Tel: 01903 737756
Email: planning@arun.gov.uk
www.arun.gov.uk/planning
Please ask for: Mrs D Johnson
Email: daun.johnson@arun.gov.uk
Telephone: 01903 737762
Our Ref: FP/55/26/PL
Your Ref:
Date: 18th May 2026

Application for Planning Permission

Development: Demolition of garage and conservatory, extension and alteration of existing bungalow to create two separate dwellings including a new crossover to public highway.

Location: 6 Ormesby Crescent Felpham PO22 8EN

Proposed Extension and New Dwelling
at 6 Ormesby Crescent, Felpham
for Mr J Bryant & Mr S Bryant
Drawing P01a June 2025 Scale 1:100 @ A3
Planning Drawing - Proposed Floor Plan & Elevations

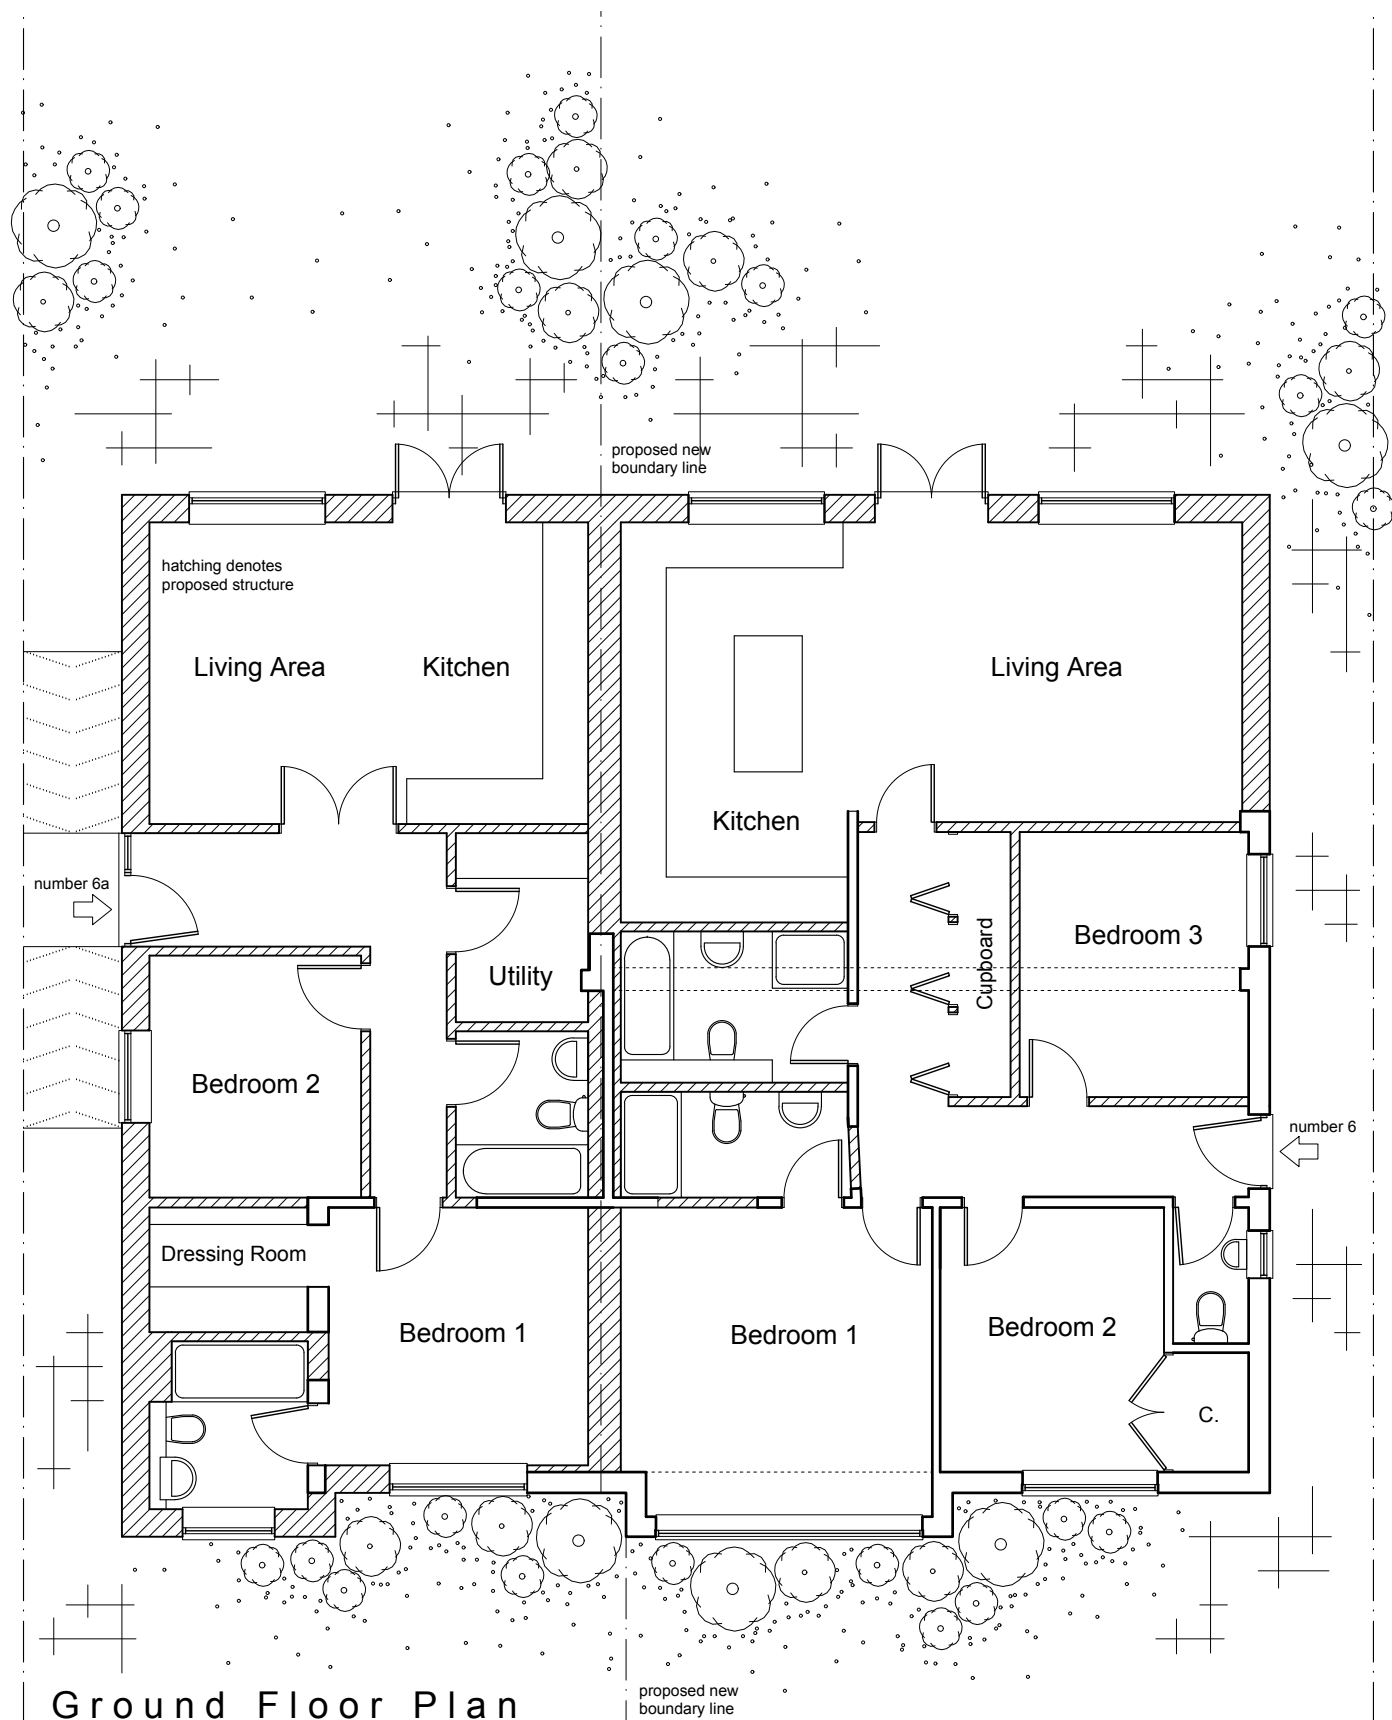
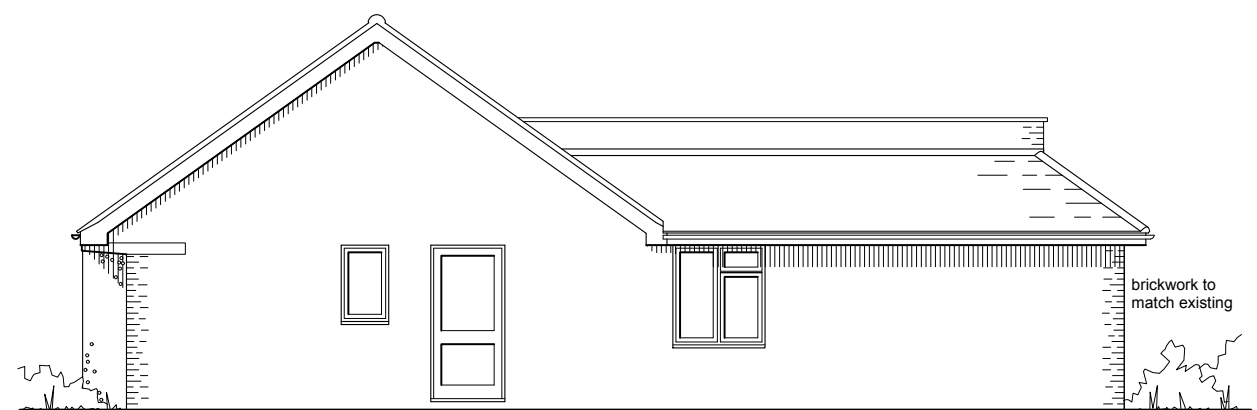
The proposed floor plan and south elevation do not accord. The WC window is in the incorrect position. Please amend accordingly.
